October 23, 2019

Re: Apartments for Ahmet Tiryaki
5550 ZIA Rd. NE
Traffic Circulation Layout
Engineer's/Architect's Stamp 01-09-2018 (K18D105)

Based upon the information provided in your submittal received 10-122-19, the above referenced plan cannot be approved for Building Permit until the following comments are addressed:

DRAWING TITLE: TRAFFIC CONTROL LAYOUT

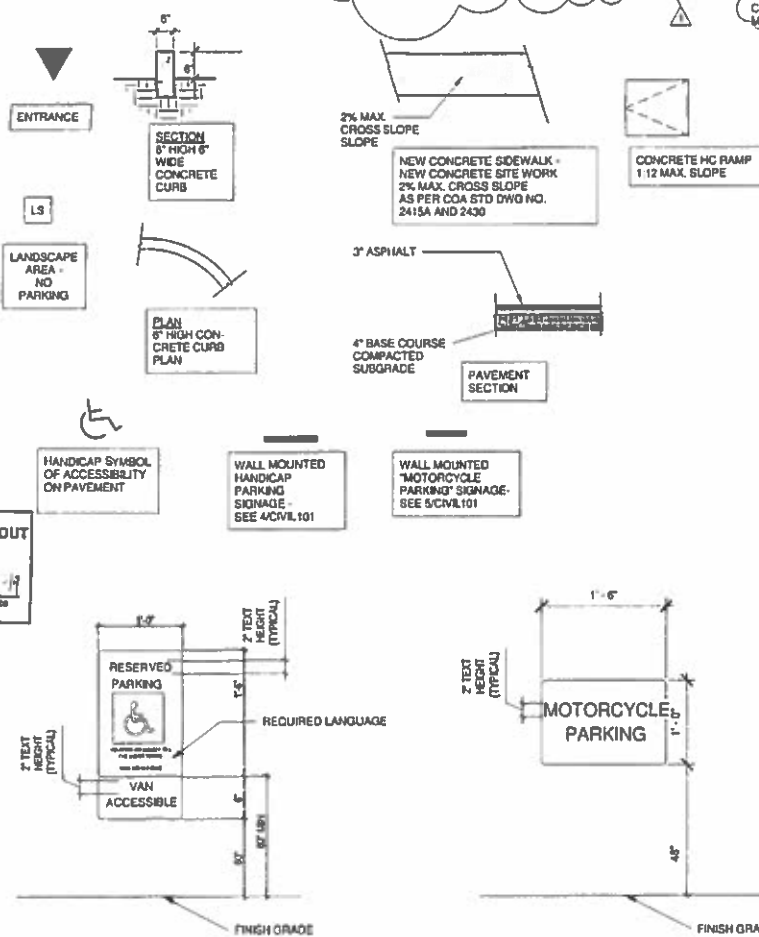
1. Please list the width and length for all existing and proposed parking spaces. Some dimensions are not shown.
2. Show the lot lines. A replat may be required.

3. **ADA curb ramps must be updated to current standards and have truncated domes installed.**
4. All bicycle racks shall be designed according to the following guidelines:

- a. The rack shall be a minimum 30 inches tall and 18 inches wide.
 - b. The bicycle frame shall be supported horizontally at two or more places. Comb/toaster racks are not allowed.

- c. The rack shall be designed to support the bicycle in an upright position. See the IDO for additional information.
 - d. The rack allows varying bicycle frame sizes and styles to be attached.

- e. The user is not required to lift the bicycle onto the bicycle rack.
 - f. Each bicycle parking space is accessible without moving another bicycle.

5. Bicycle racks shall be sturdy and anchored to a concrete pad.
6. A 1-foot clear zone around the bicycle parking stall shall be provided.
7. Bicycle parking spaces shall be at least 6 feet long and 2 feet wide.

8. Refuse vehicle maneuvering shall be contained on-site. The refuse vehicle shall not back into the public right of way.; **provide a copy of refuse approval.**

9. Show the clear sight triangle and add the following note to the plan: "Landscaping and signage will not interfere with clear sight requirements. Therefore, signs,

walls, trees, and shrubbery between 3 and 8 feet tall (as measured from the gutter pan) will not be acceptable in the clear sight triangle.
